# VOLLMER ROAD (BARBARICK) - INTERIM CONDITION

### STREET IMPROVEMENT PLAN

#### JULY 2023

**VOLLMER ROAD (BARBARICK) – INTERIM CONDITION**  
**CROSS SECTIONS**

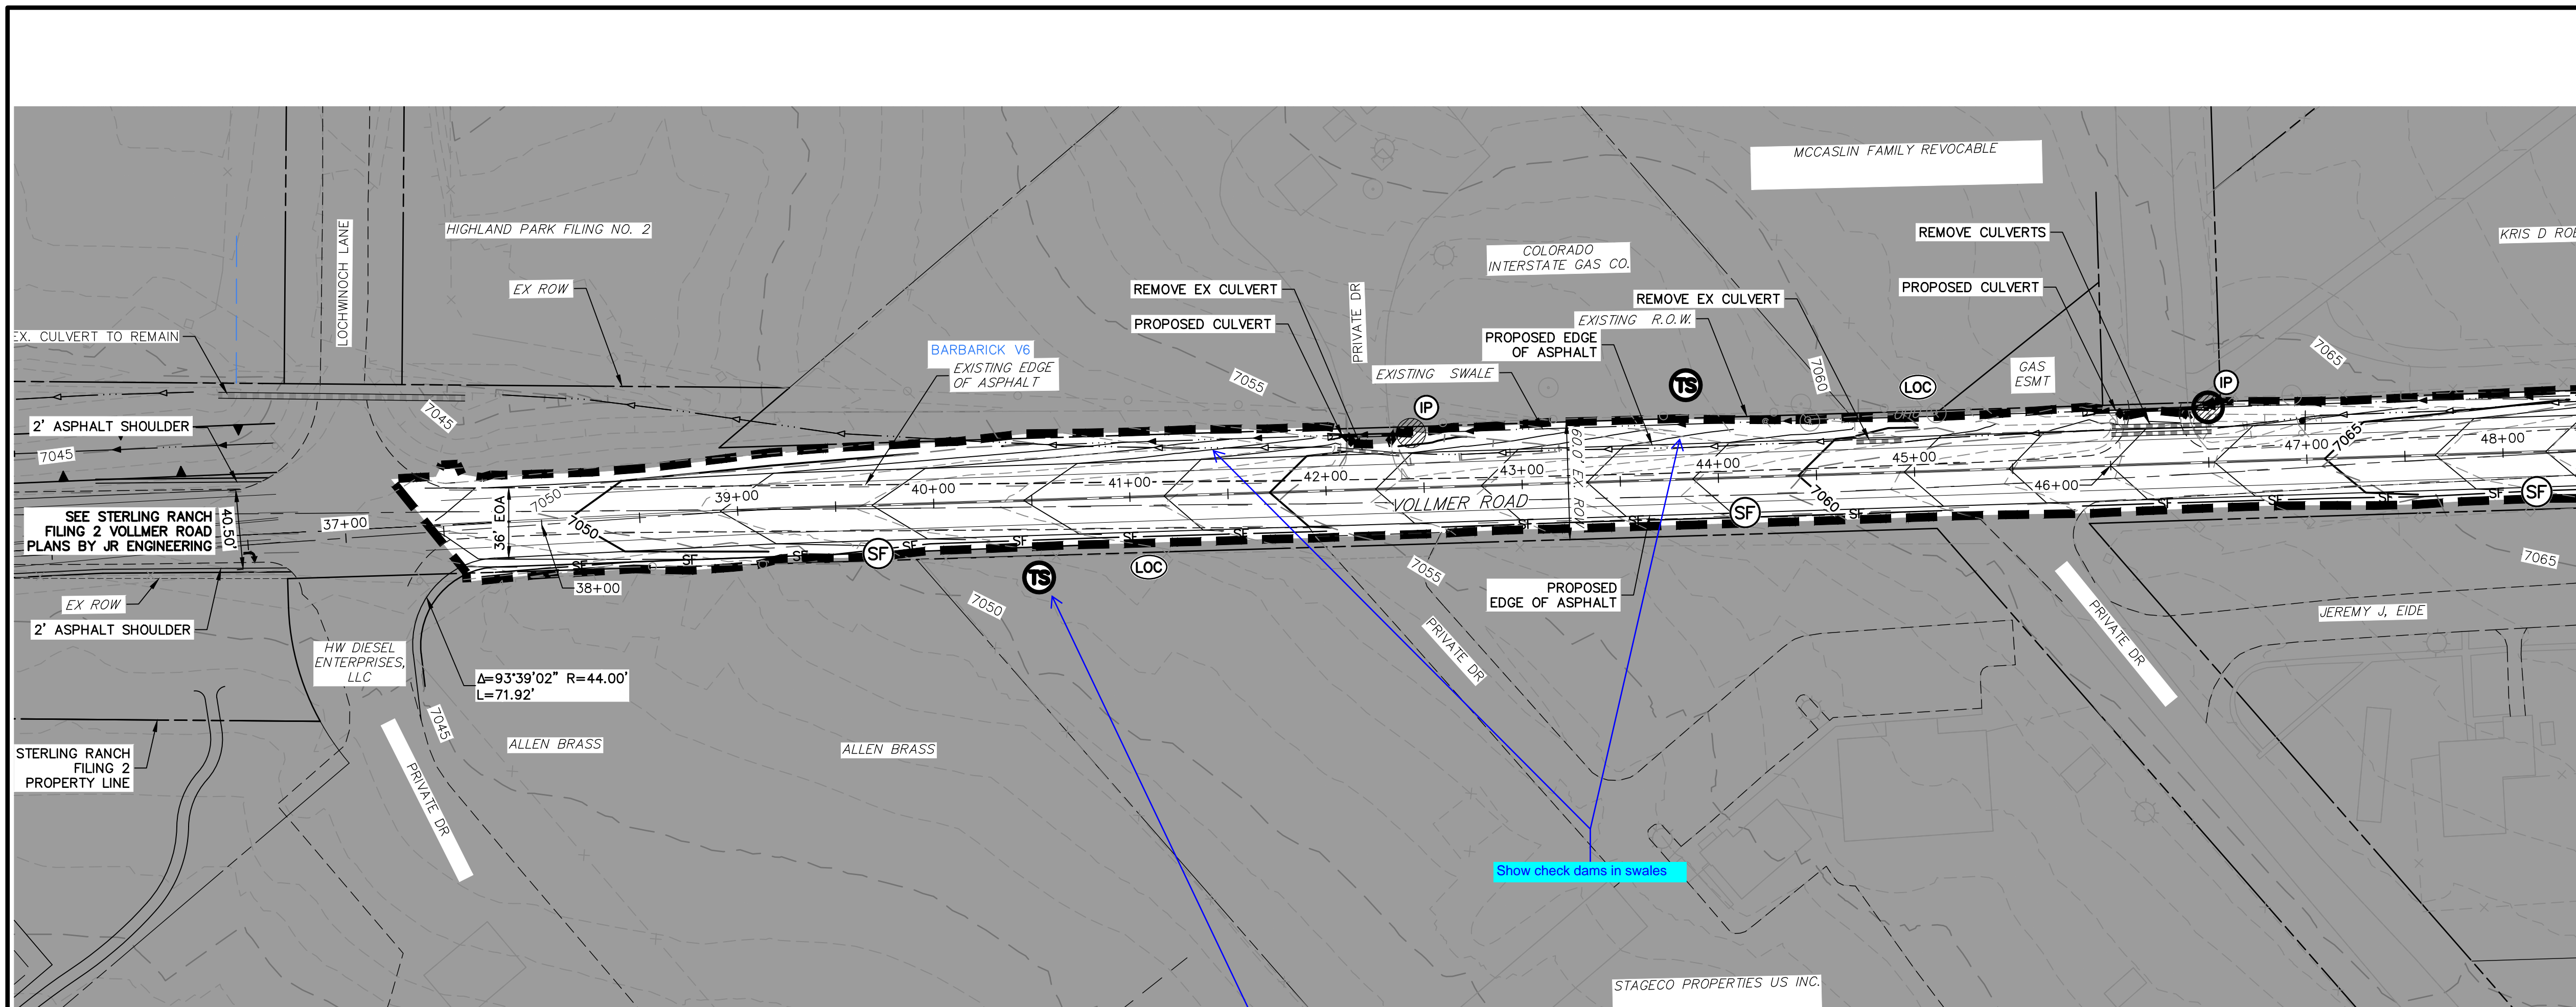
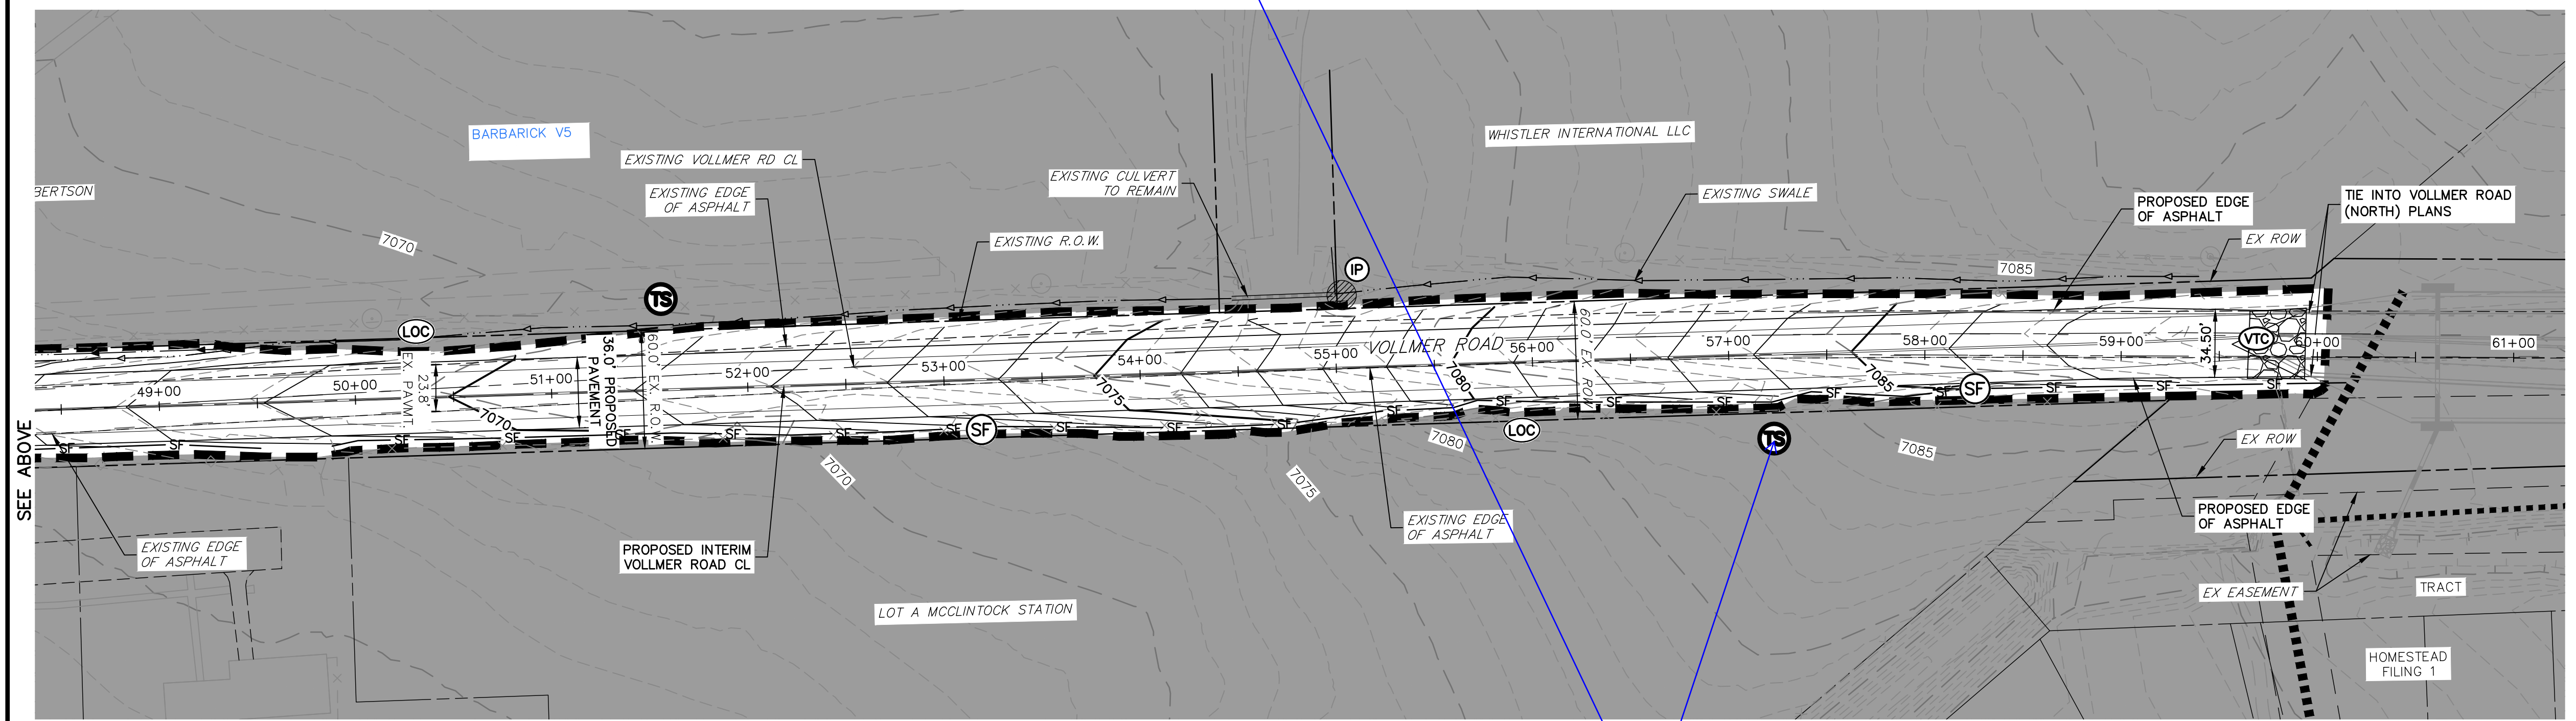
The interim cross section should show the existing roadway and the proposed widening section clearly distinguished.

JR Response: the existing road section varies in width and in location as compared to the proposed section. Existing road label added to interim cross section
